**Transport  
for NSW**

**Re-Exhibition of Application for Remediation Works for Block 5 within the EPA  
Declaration Area and Adjacent Areas at Barangaroo (SSD 6533)**

TfNSW provides the following comments on the development application.

Remediation and Land Forming Works
Development Application - Block 5 Remediation
Earthworks Drawing

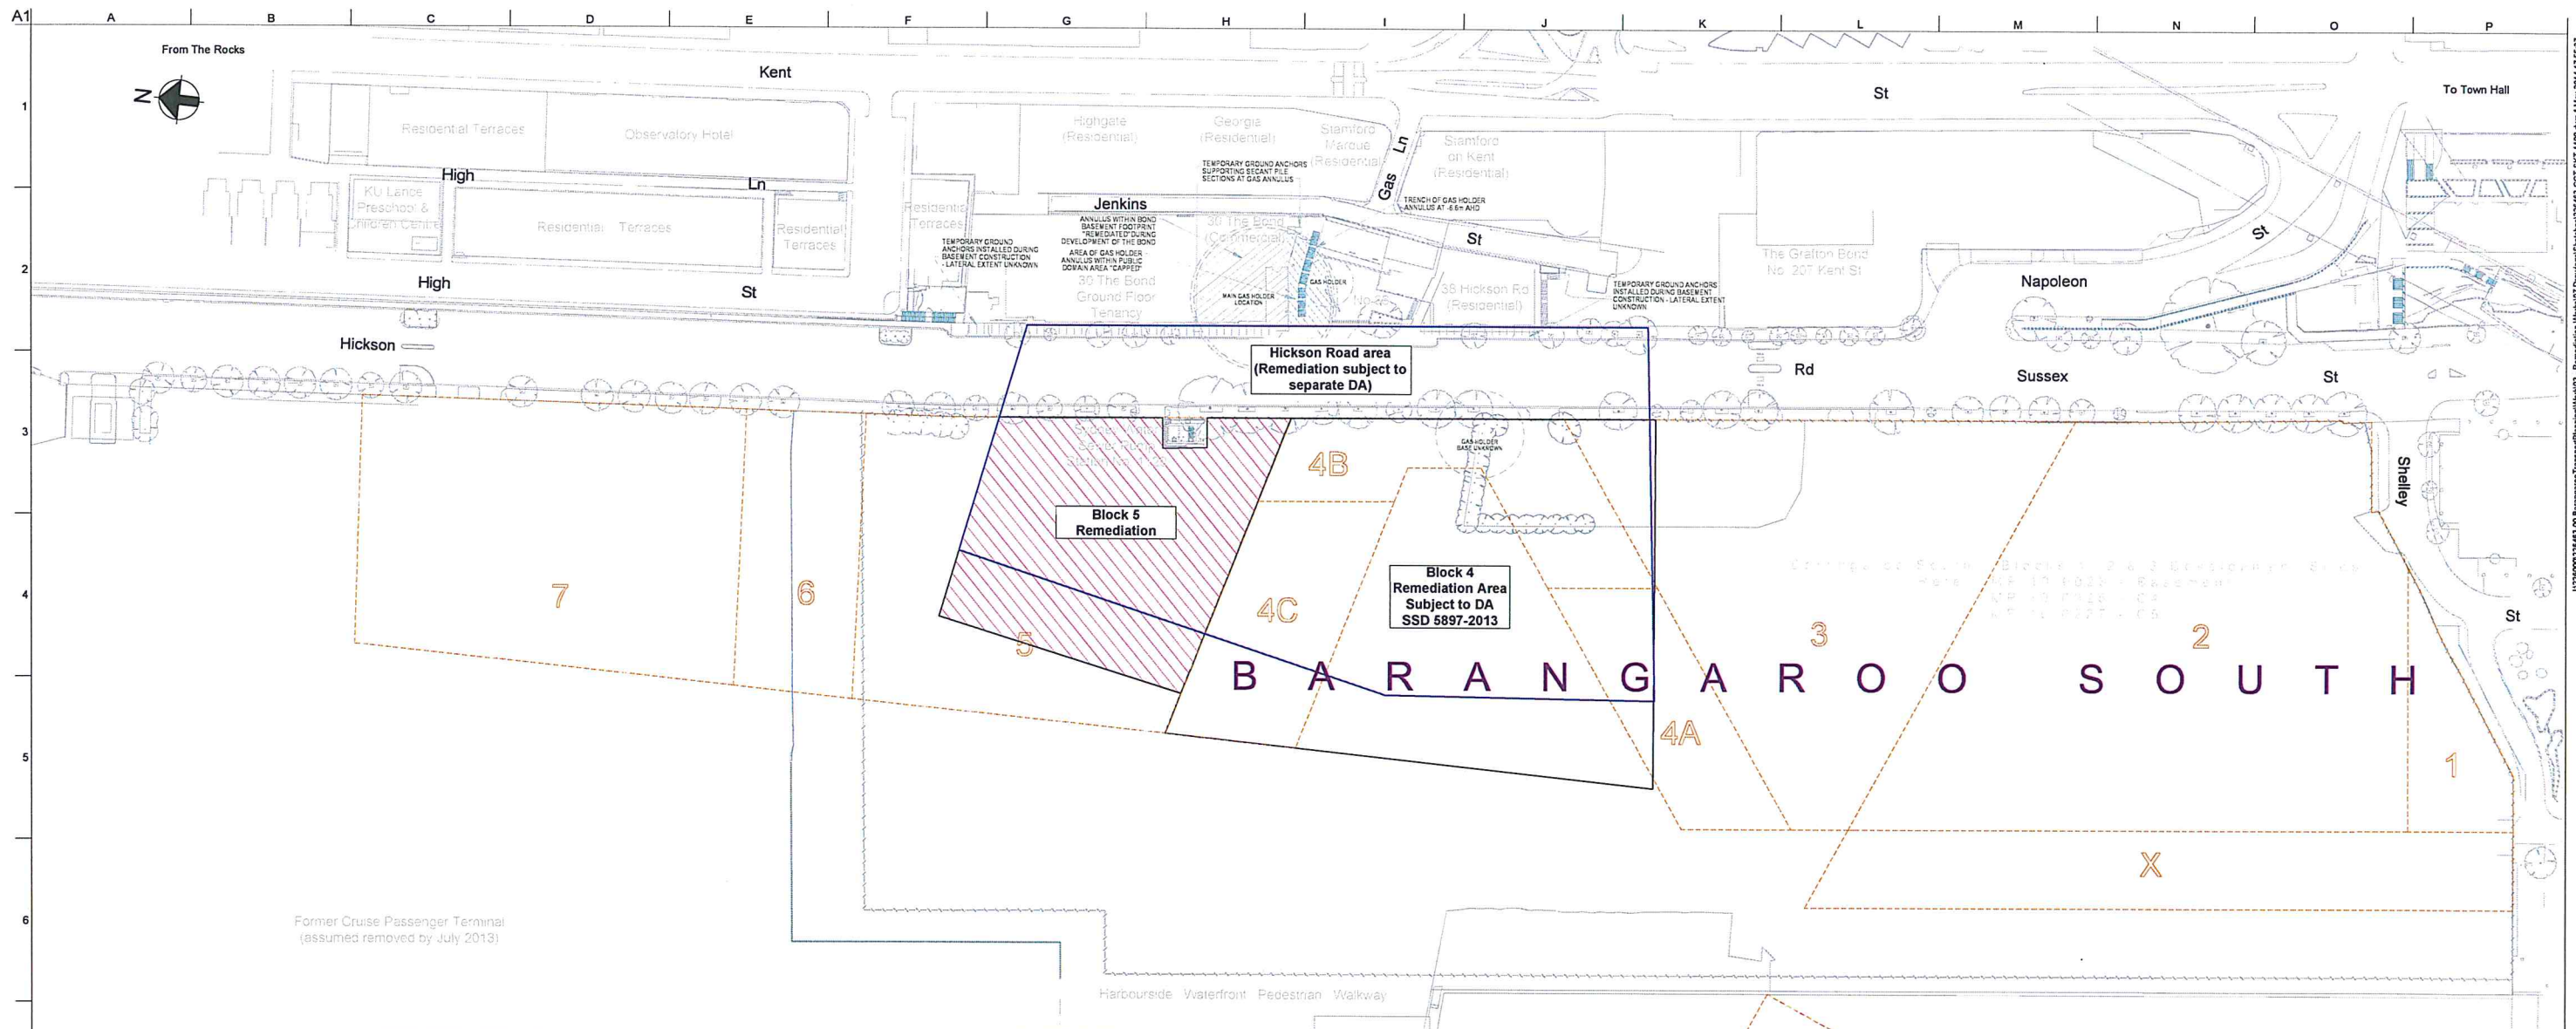
The diversion and augmentation of existing storm water infrastructure will be undertaken on Hickson Road. Any road/lane closures for drainage works on Hickson Road could have the potential to impact on traffic movements, safety of pedestrians and cyclists and bus operation along Hickson Road.

A Road Occupancy Licence (ROL) must be obtained from the Transport Management Centre (TMC) for any activity likely to impact on the operational efficiency of the road network. The ROL allows the applicant to use a specified road space at approved times, provided certain conditions are met.

Proponents must allow a minimum of 10 working days for processing from date of receipt. Traffic Control Plans are to accompany each ROL application.
